**WELWYN HATFIELD BOROUGH COUNCIL  
EXECUTIVE DIRECTOR - PLANNING, PUBLIC PROTECTION AND GOVERNANCE**

**Application No:** 6/2019/0728/HOUSE  
**Location:** 111 Eddington Crescent Welwyn Garden City AL7 4SX  
**Proposal:** Installation of a dormer window to facilitate a loft conversion  
**Officer:** Mr A Commenville

**Recommendation:** Refused

Date of this revision: -		
drawn by: KRS	drawn date: MAR 19	scale: 1:100 @ A3
project: 111 EDDINGTON CRESCENT WELWYN GARDEN CITY, HERTS AL7 4SX		
client: MR & MRS N HAMBRIDGE		
dwg title: EXISTING AND PROPOSED ELEVATIONS		
dwg no: 2437 PL 04		rev: -

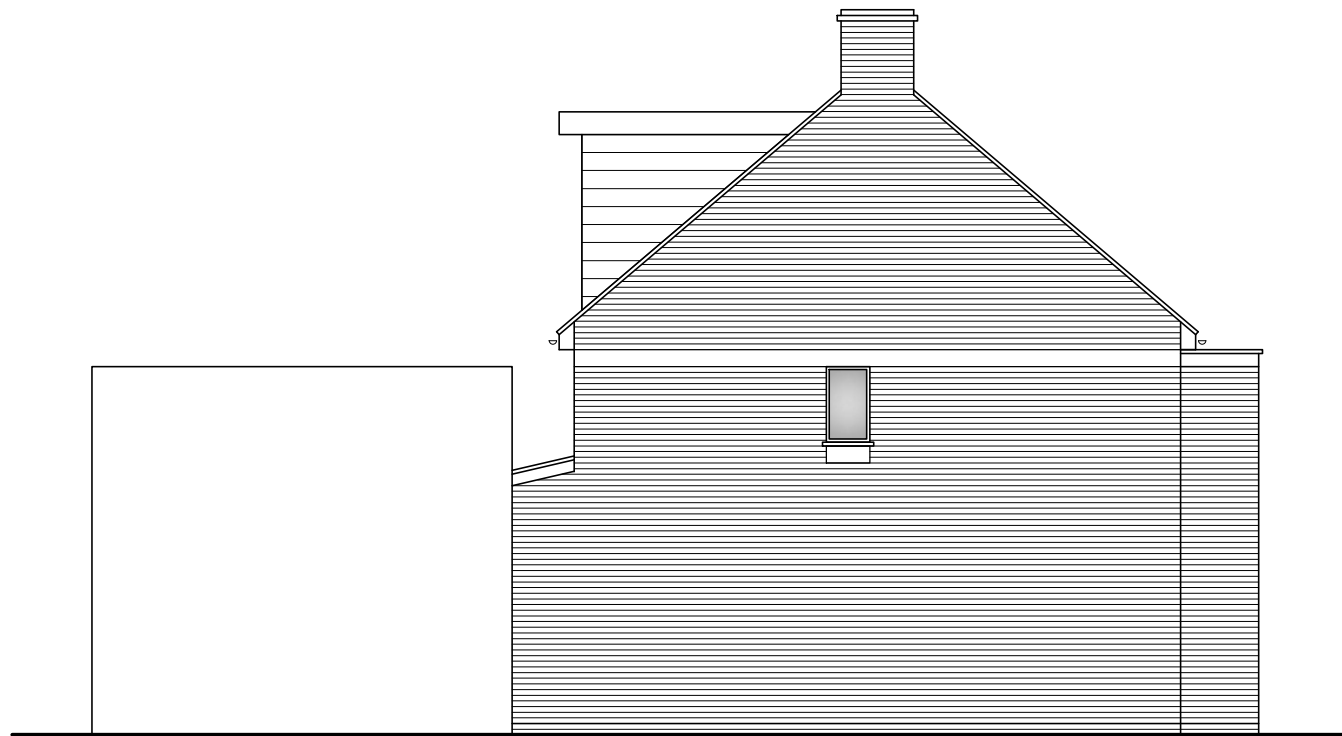
The proposed dormer would be contained within the roof slope and would appear subservient to the roof of the dwelling. The proposal would respect the character and appearance of the dwelling, and surrounding area. Furthermore, given its siting within the streetscene, it would not be highly visible from the streetscene.

It is acknowledged that the amount of glazing proposed would result in an additional impact and some overlooking towards No.113 Eddington Crescent rear amenity space. However, while it is noted that no objections have been received, it is also noted that the extent of overlooking would be consistent with a neighbouring relationship generally expected between residential properties and would be to some extent comparable to the views from the existing first floor windows. It is therefore not considered that the scope of additional overlooking would be sufficient to be considered unacceptably harmful to the privacy of the occupants of No. 113.

dwg title:
 LOCATION PLAN, EXISTING AND PROPOSED SITE AND ROOF PLANS

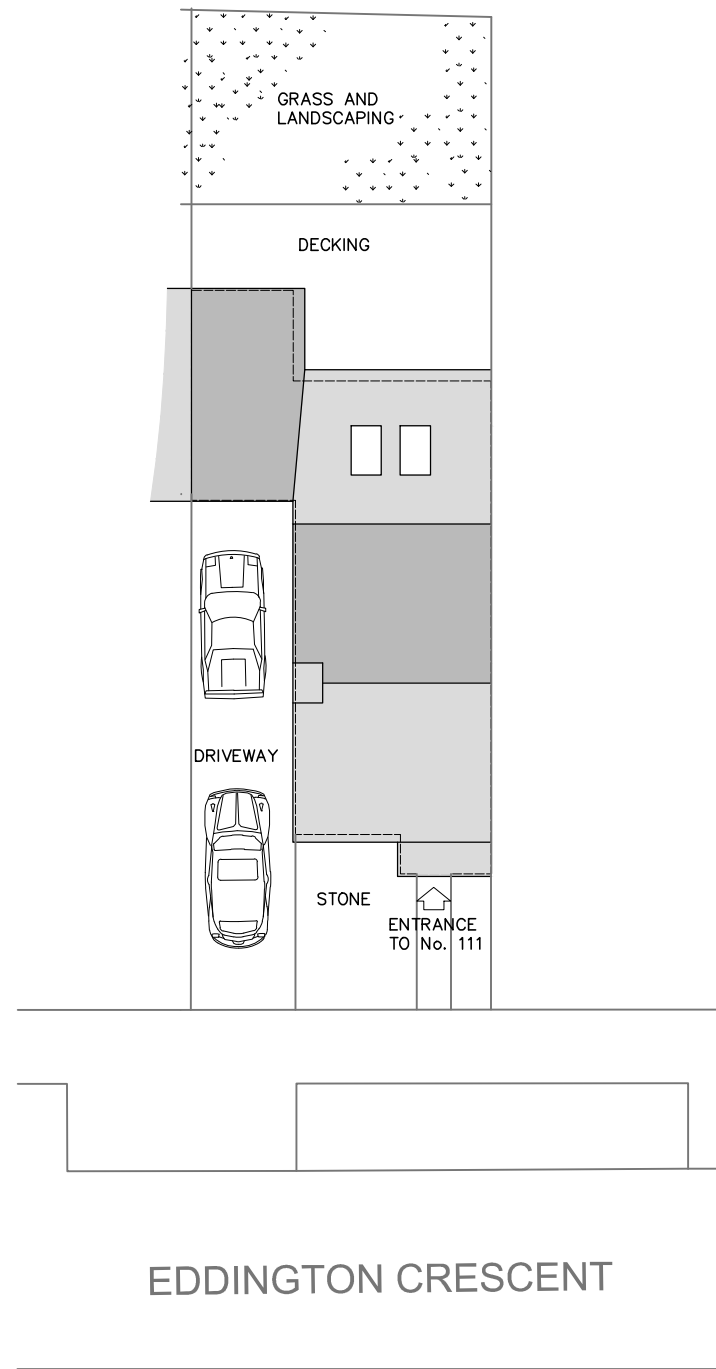
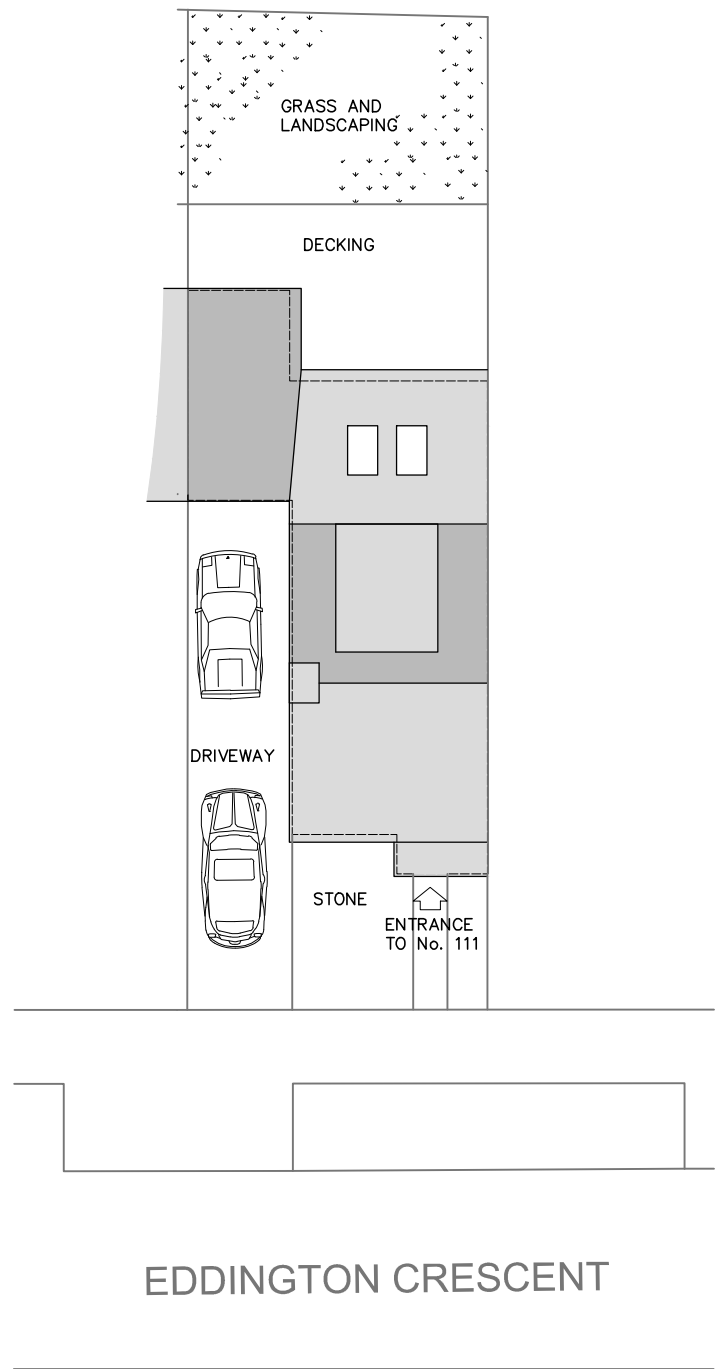
The property once extended would be a 4 bedroom property. Three on site car parking spaces are

required. Two parking spaces are available on site. However, no plan has been put forward which indicates 3 on-site car parking spaces on the frontage.

No supporting statement has been provided to justify the shortfall of car parking spaces on site. The Case Officer made an assessment of the local area on the site visit and it is noted that there are no parking restrictions. However, the road is narrow with numerous dropped kerbs and evidence of on-street car parking pressures within Eddington Crescent and wider estate during working hours where it is expected that on-street demand would be less. The potential for an additional car parking on the road would add to the parking pressures within the vicinity and consequently would exacerbate the existing problems of inconvenience to pedestrians. Furthermore, if planning permission were to be granted it would be difficult to resist similar applications from neighbouring properties. Although each proposal must be considered on its own merits, repetition of this type of development would result in a cumulative impact which would be likely to further increase the stress on parking provision within the locality resulting in a harmful effect on the character of the area.
